CITY OF ALBUQUERQUE

**RE: MDS - Montage Subdivision Unit 7 on Bobby Foster
Grading and Drainage Submittal for Preliminary Plat and Grading Permit
Engineer's Stamp Date: 6/30/22
Hydrology File: R16D100A**

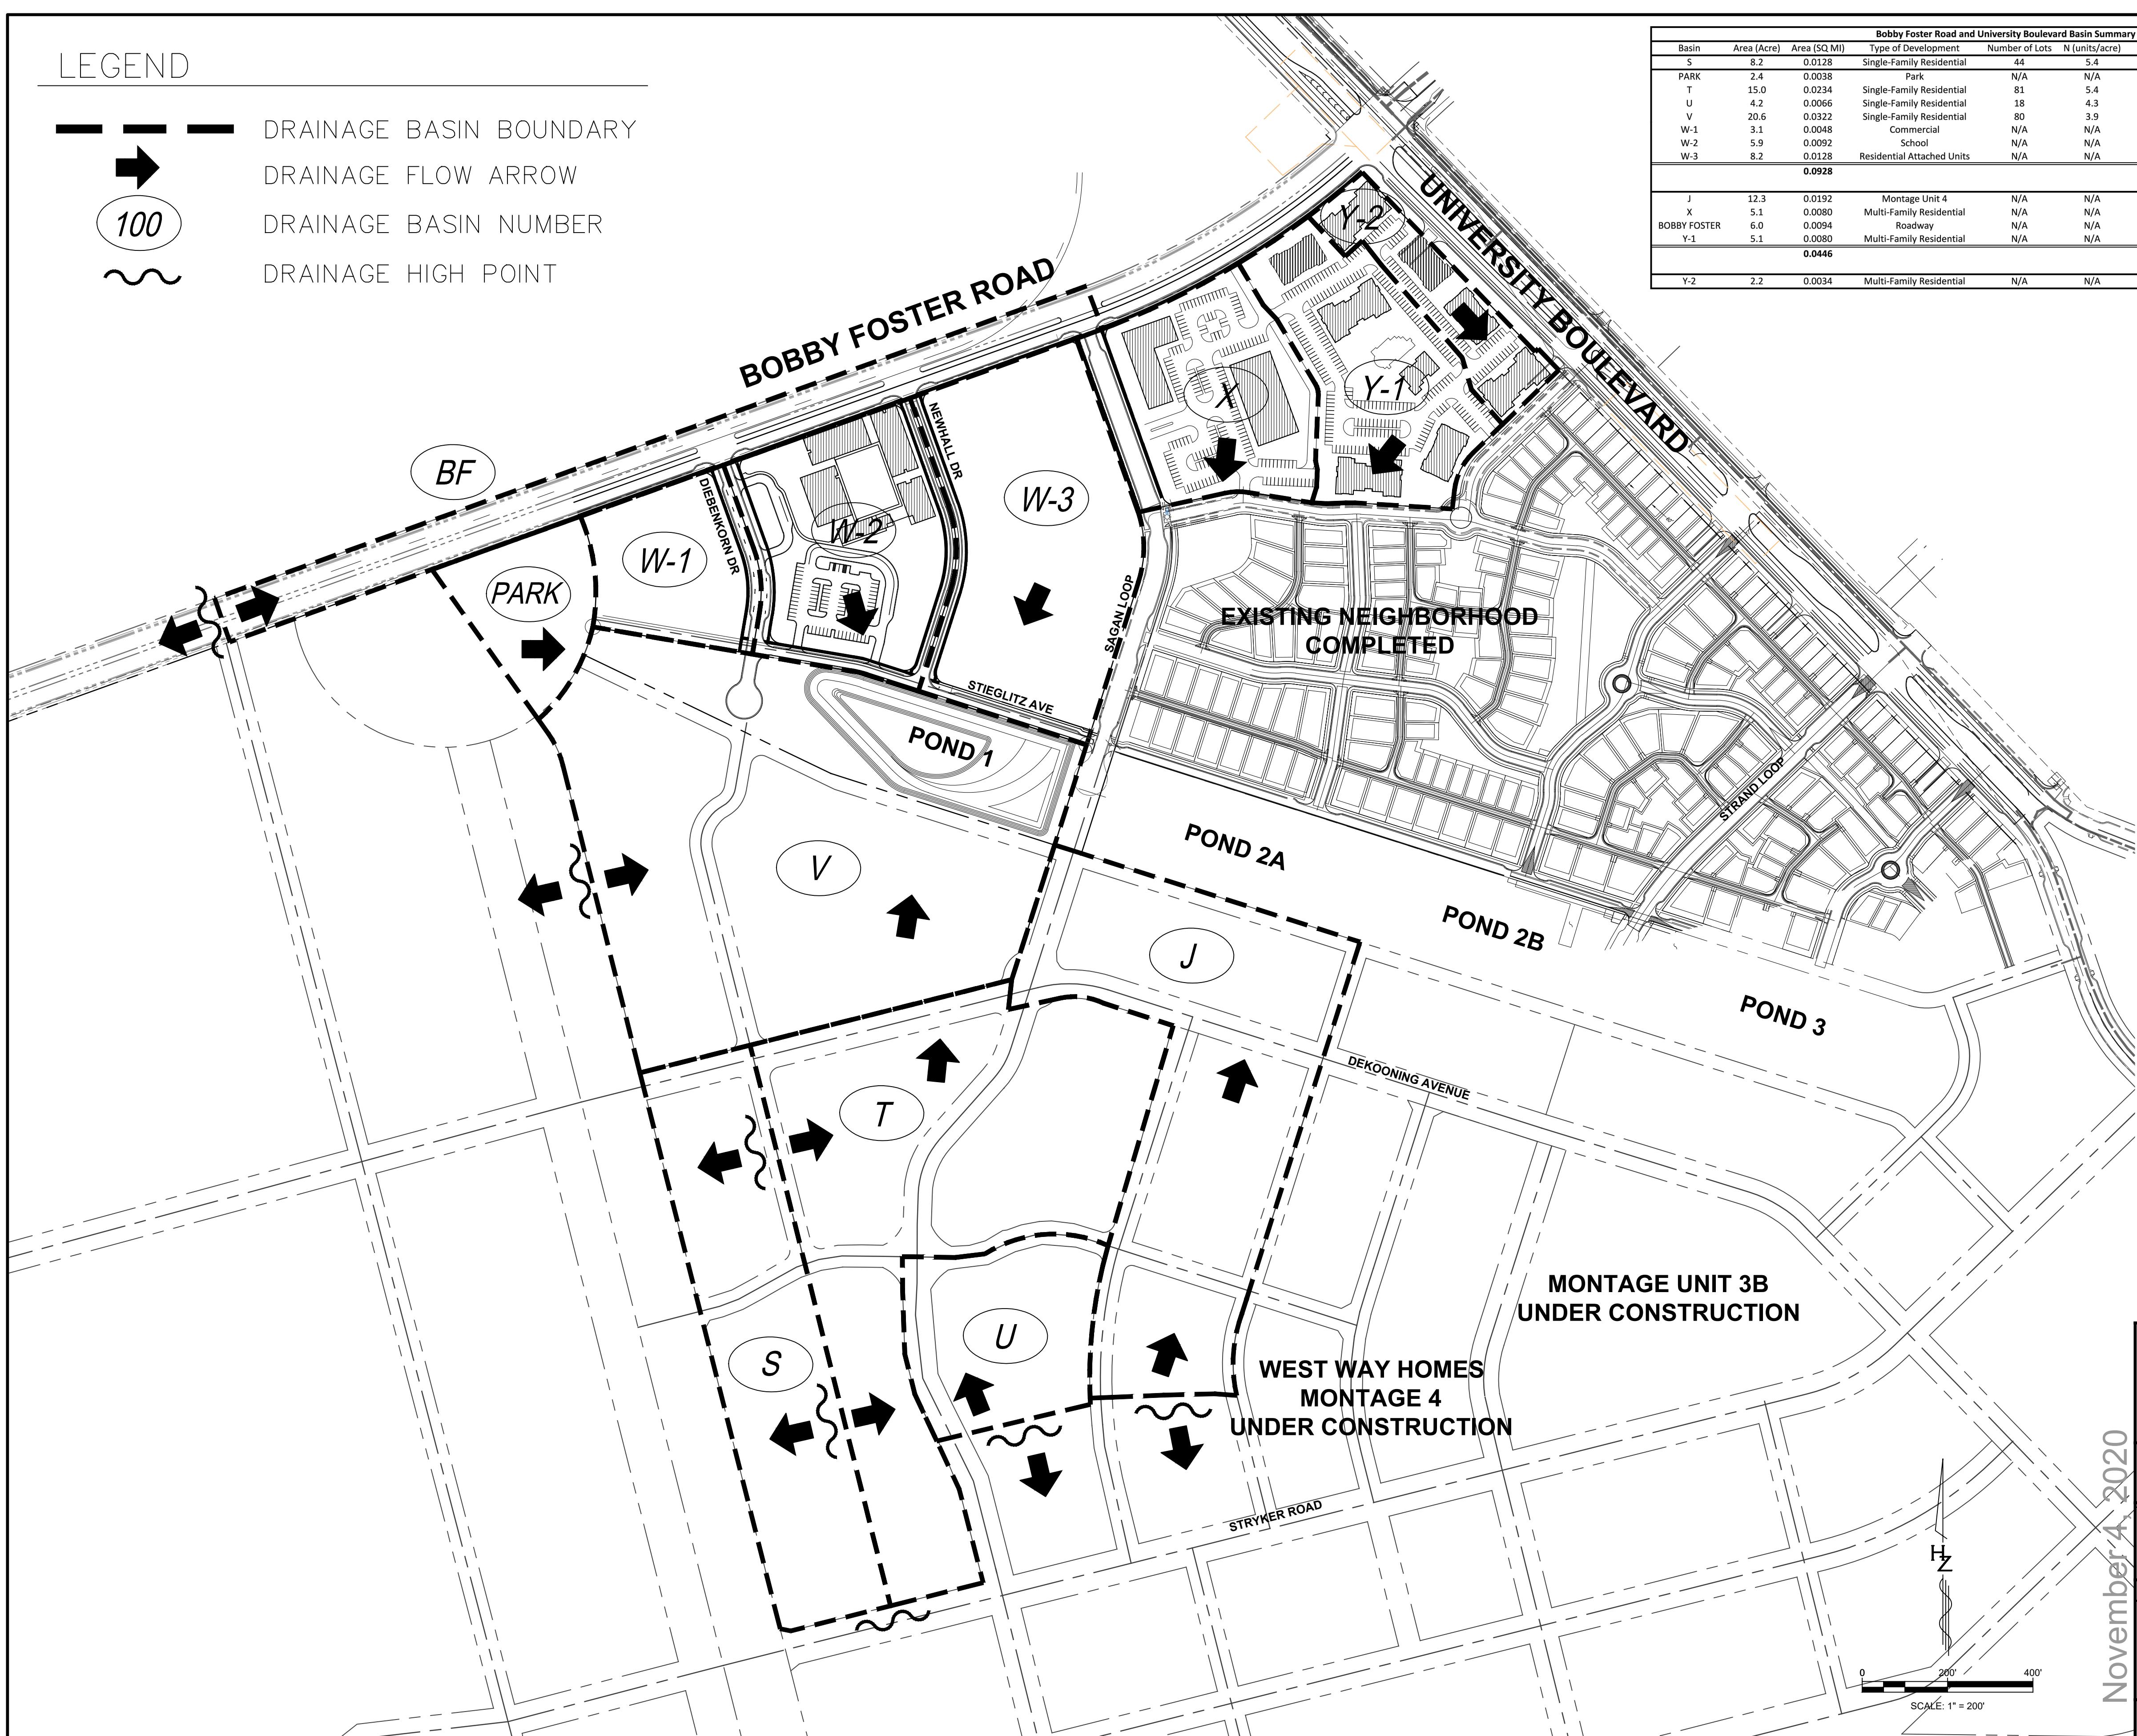
4. The analysis of the Bobby Foster project, hydrology # R16D100 must be updated to reflect the as-built condition where most of Basin "BF" drains down Diebenkorn Dr. and Newhall Dr. to "Pond 1" instead of draining down Sagan Lp. to "Pond 2A" as planned in the original drainage report for Bobby Foster, hydrology file # R16D100. The drainage design and infrastructure for Montage Subdivision Unit 7 is highly dependent on the Bobby Foster Subdivision, so the stormwater quality volume SWQV calculations for the areas draining to "Pond 1" must be tabulated and the "Pond 1" volume and outfall hydraulic calculations must be added. The AHYMO file shows 2 acre-feet retention below elevation 5300 and says the outfall structure is an 18" pipe but doesn't provide volume and hydraulic calculations. They must be provided along with a detail of the outfall structure. The outfall structure was omitted from the WO plans but that condition isn't modeled in AHYMO. This analysis must be updated and approved prior to review of this Grading and Drainage Plan.
